**Consultation Response from KC,
Strategic Housing**

2025/92234 land off, Cockley Hill Lane, Kirkheaton, Huddersfield, HD5 0HH

**Variation of condition 2 (plans) on previous permission 2021/92527 for erection of 29 dwellings,
formation of access, public space, attenuation and associated infrastructure**

Date Responded: 23/09/2025

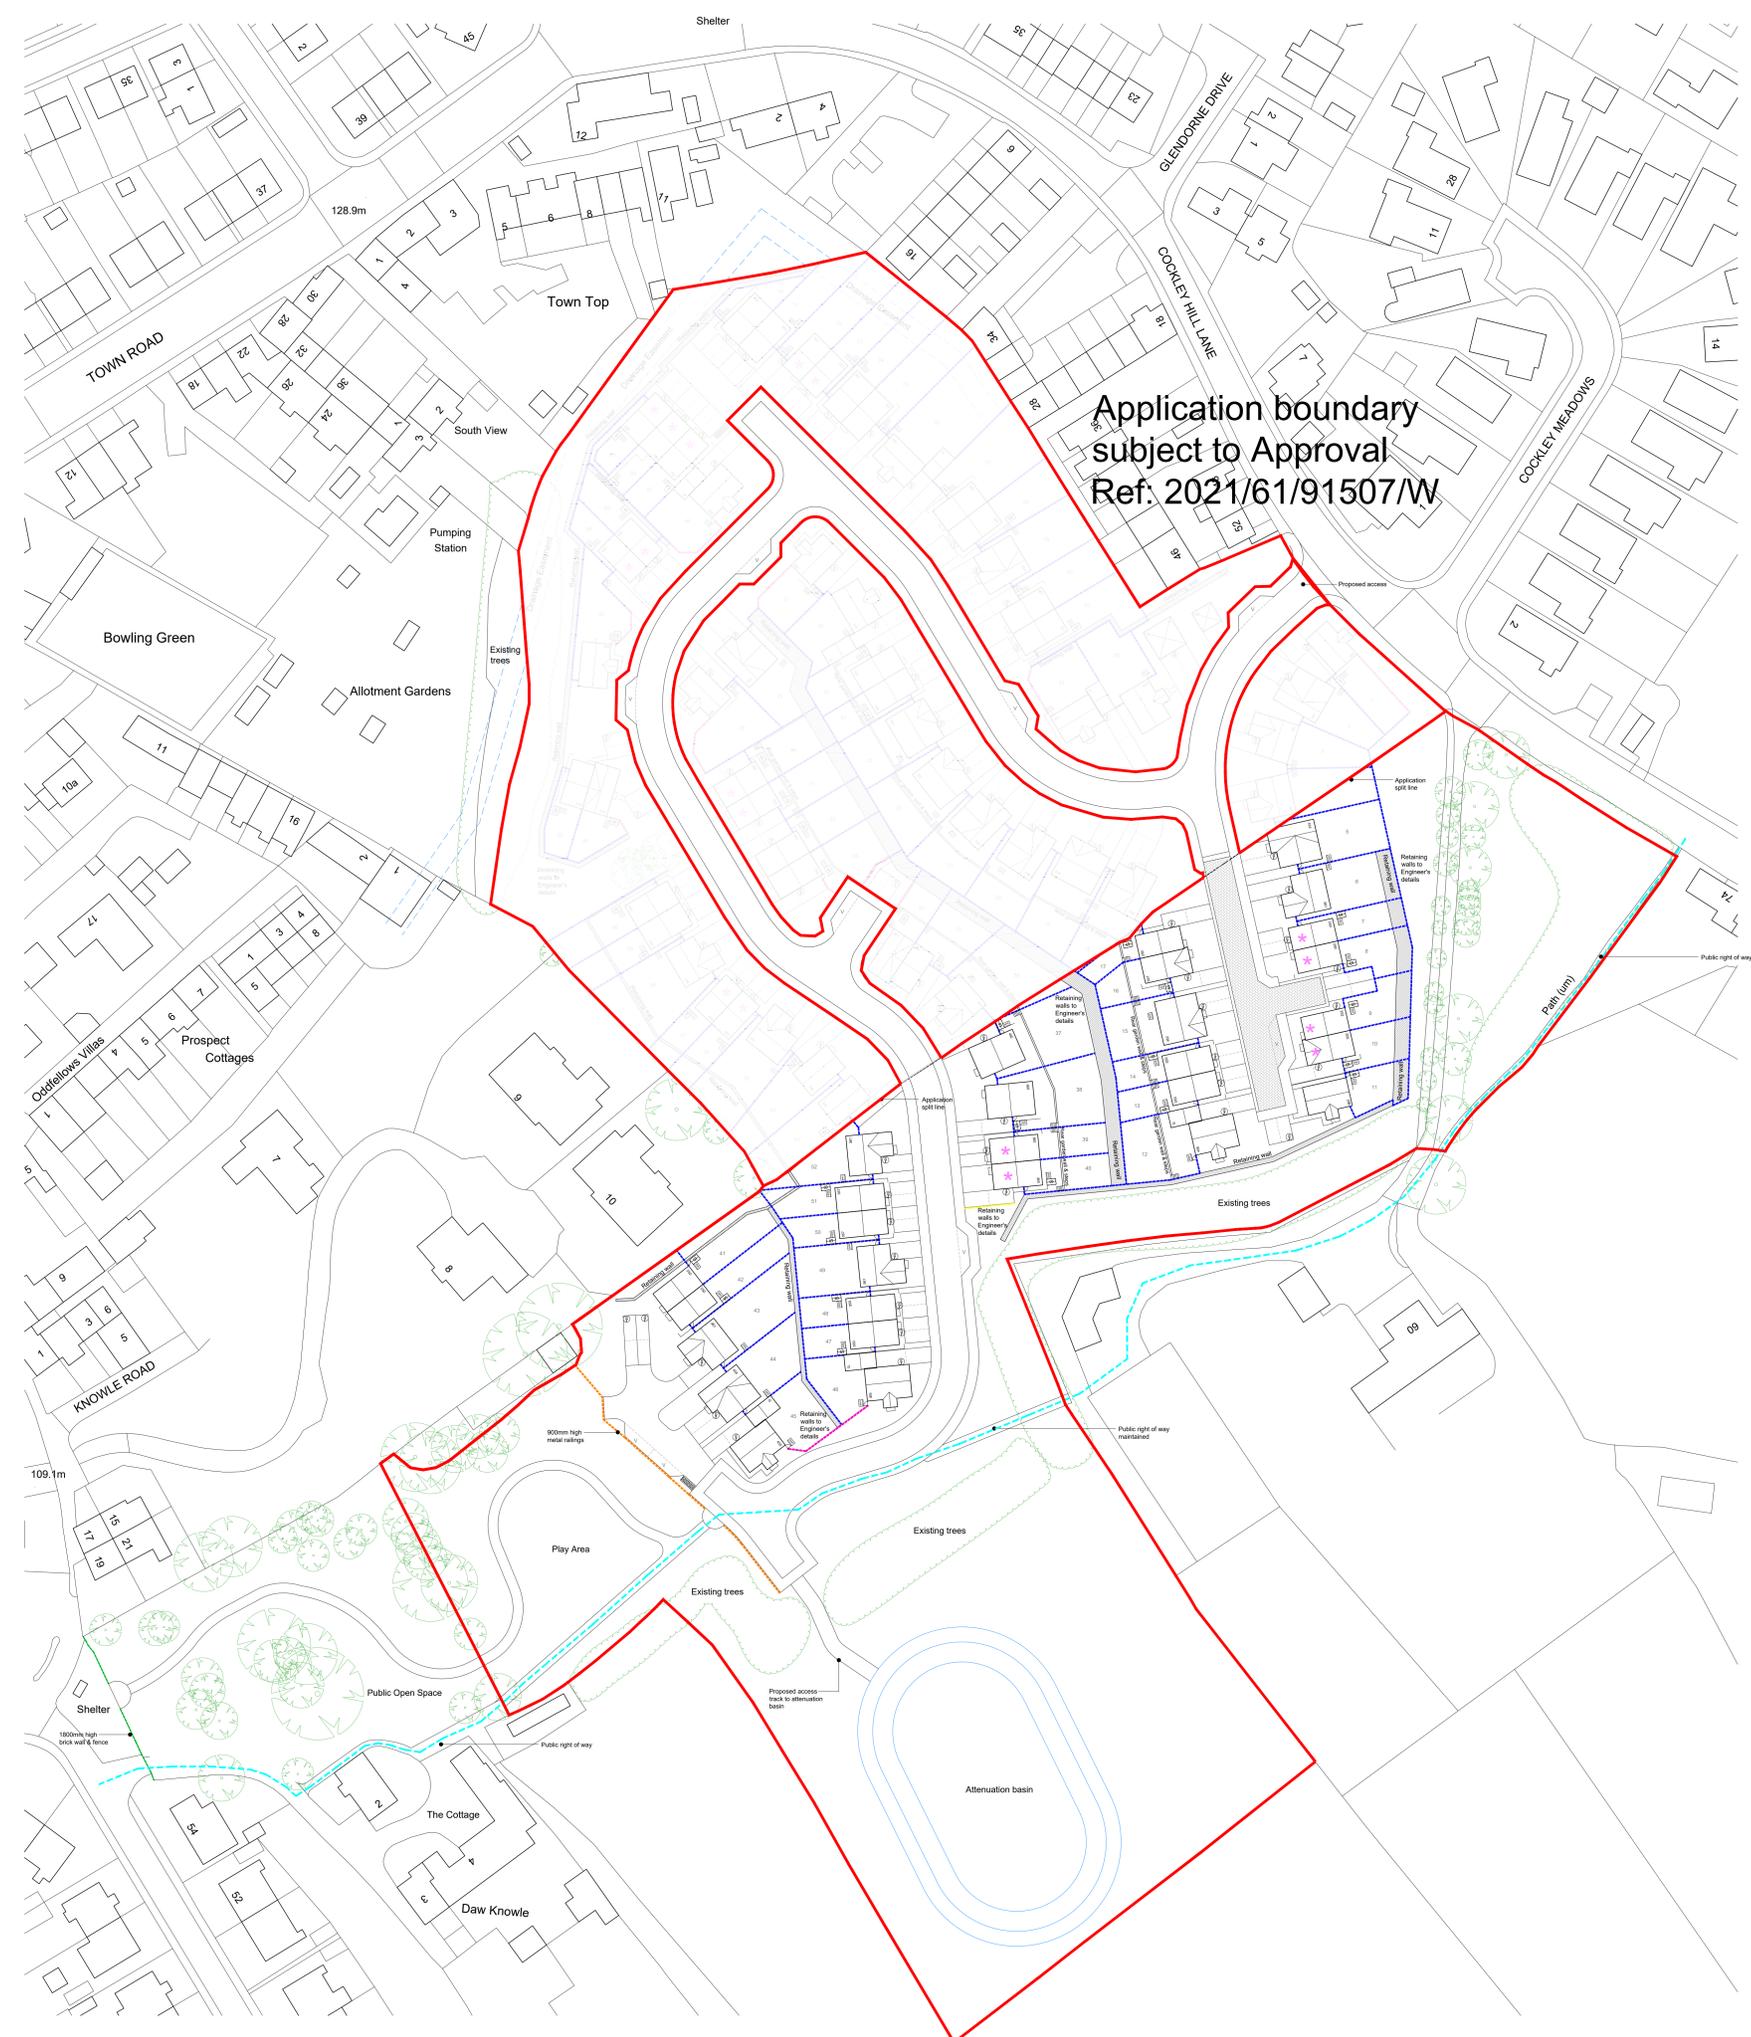
The proposed layout shows that the affordable homes are distributed evenly throughout the development and therefore, Strategic Housing does support the current proposal.

Planning
 Proposed Site Layout
 Combined Application Sites
 1187 - EA - A - C301 - F 14.07.25 1:500 (A0)

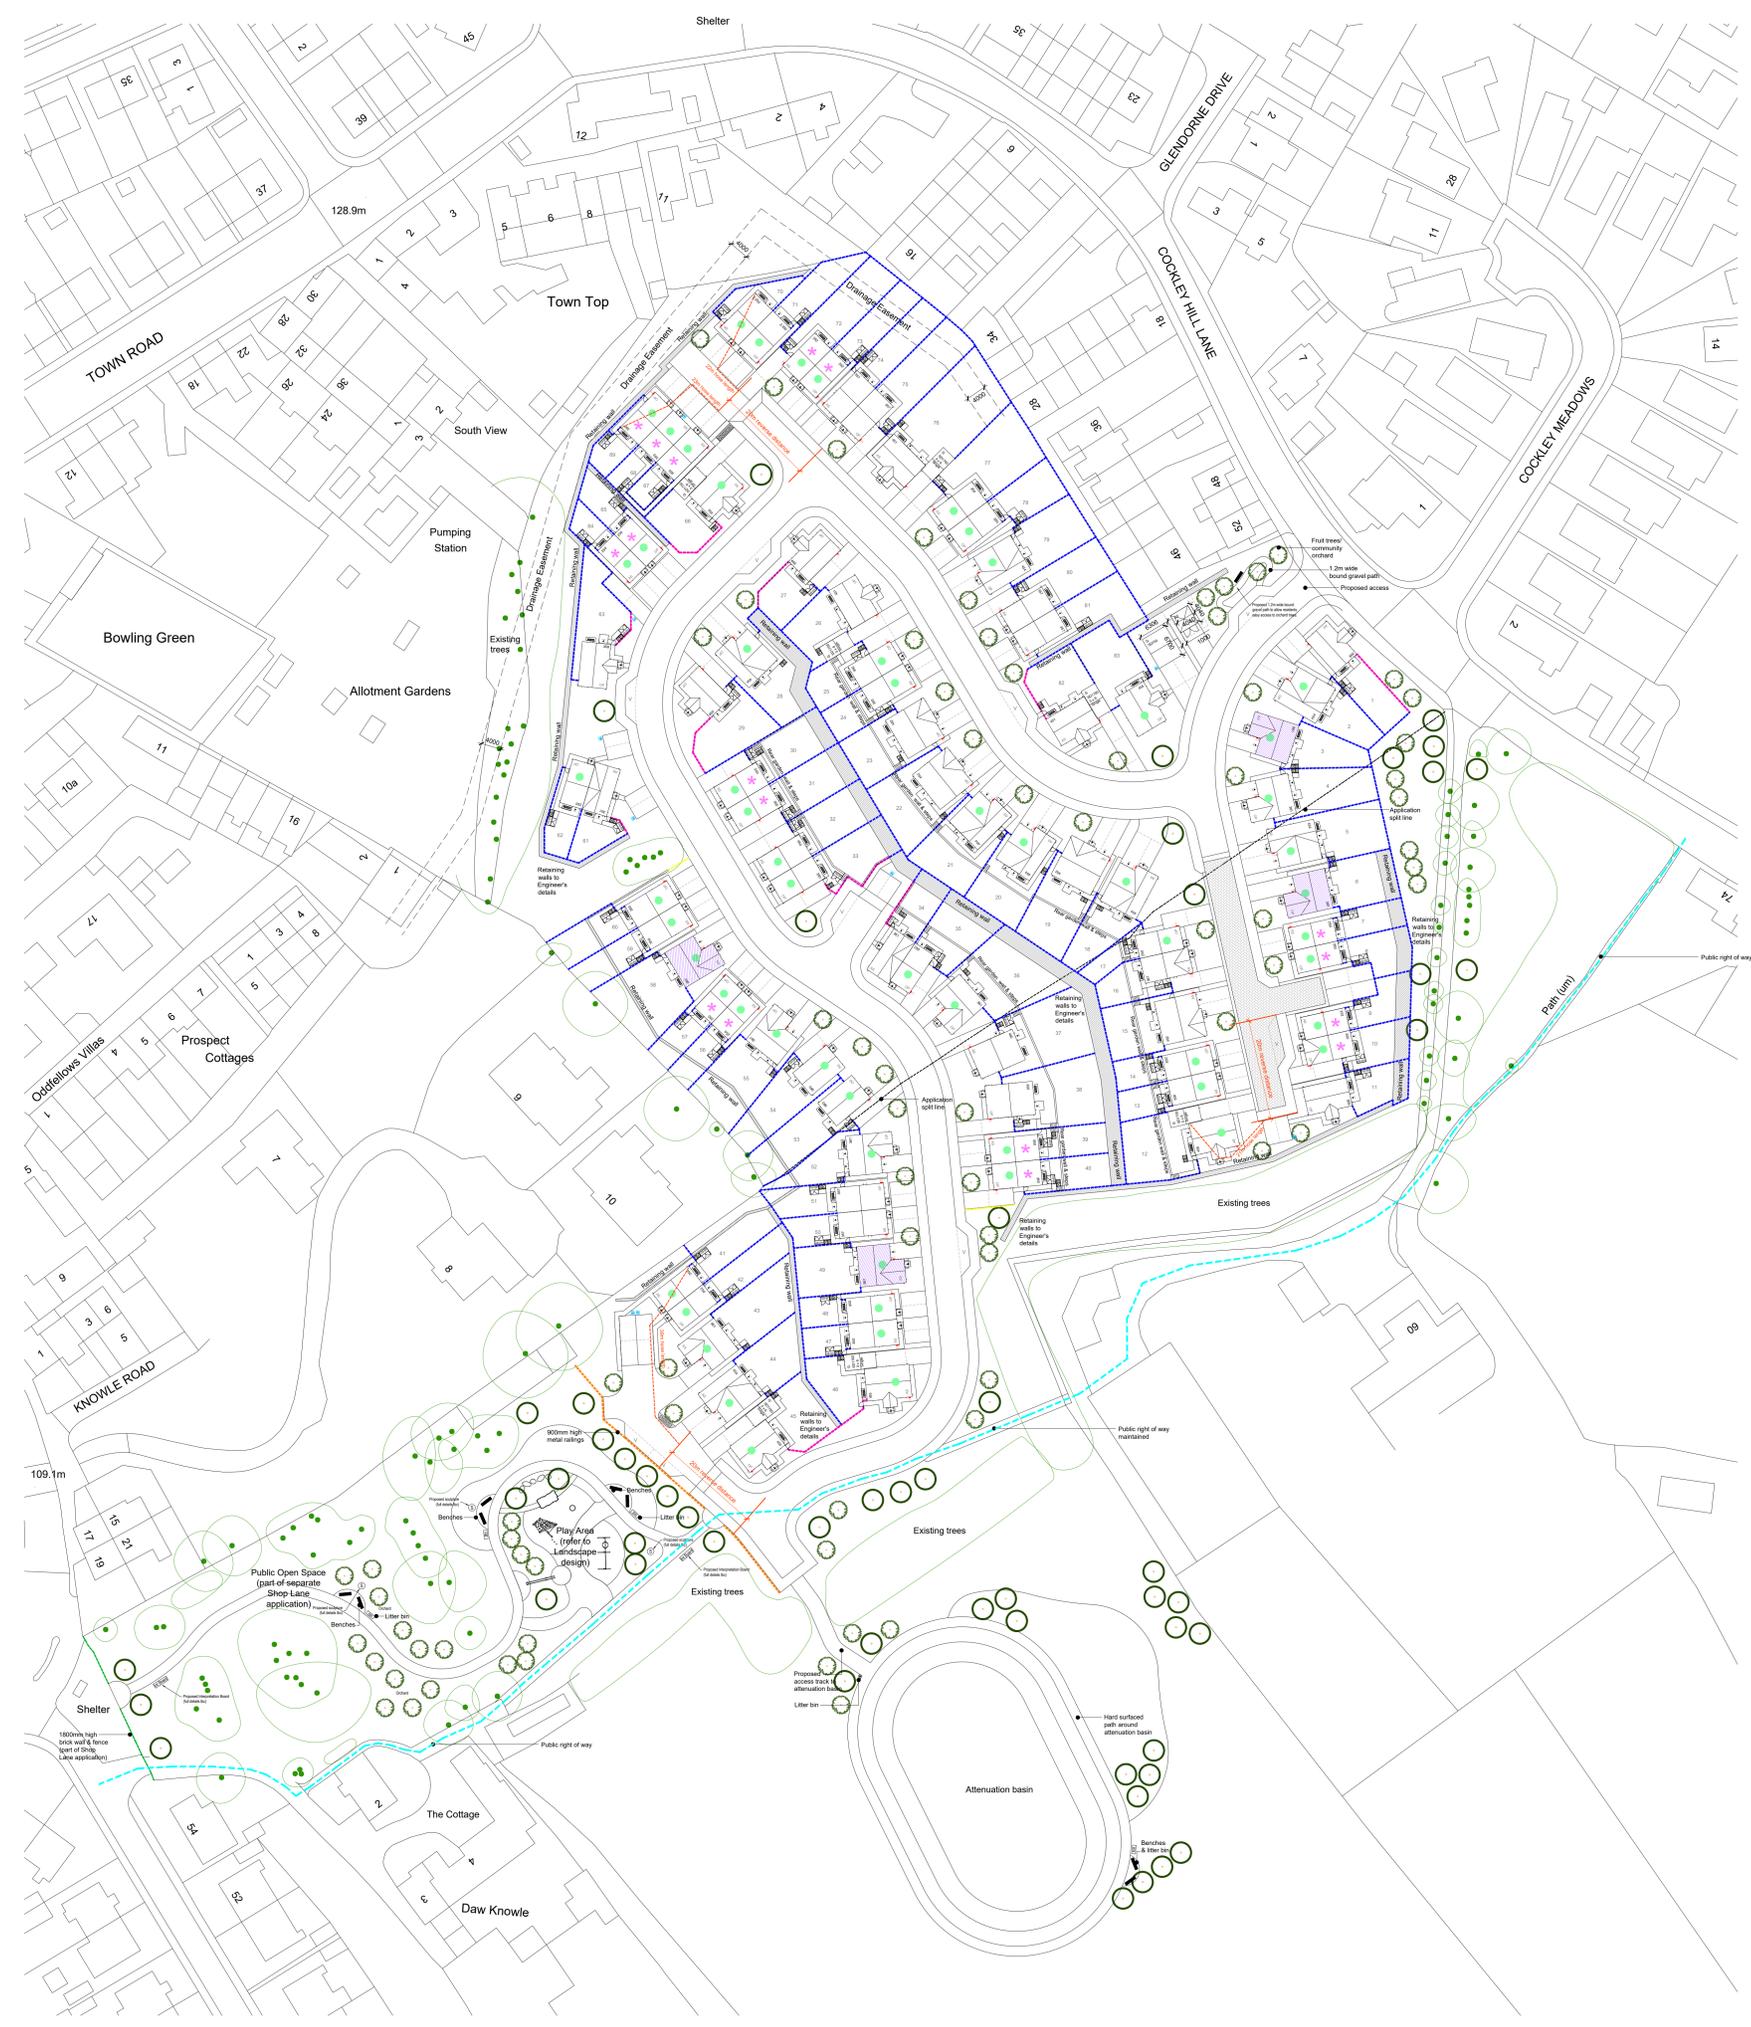
Type: The applicant proposes a mix of 2-bed, 3-bed and 4+ bed dwellings. The following table shows the proposed housing mix for each tenure.

<i>Huddersfield South</i>	Market Housing	Affordable Rent	Affordable Intermediate
1 and 2-bed	5 (8%)	7 (78%)	2 (25%)
3-bed	39 (59%)	2 (22%)	6 (75%)
4+ bed	22 (33%)	0 (0%)	0 (0%)

Strategic Housing request that the housing mix is amended to comply with the Housing Mix table for Huddersfield South set out above and in the SPD. If the applicant is unable to provide a compliant mix, evidence-based justification must be provided.
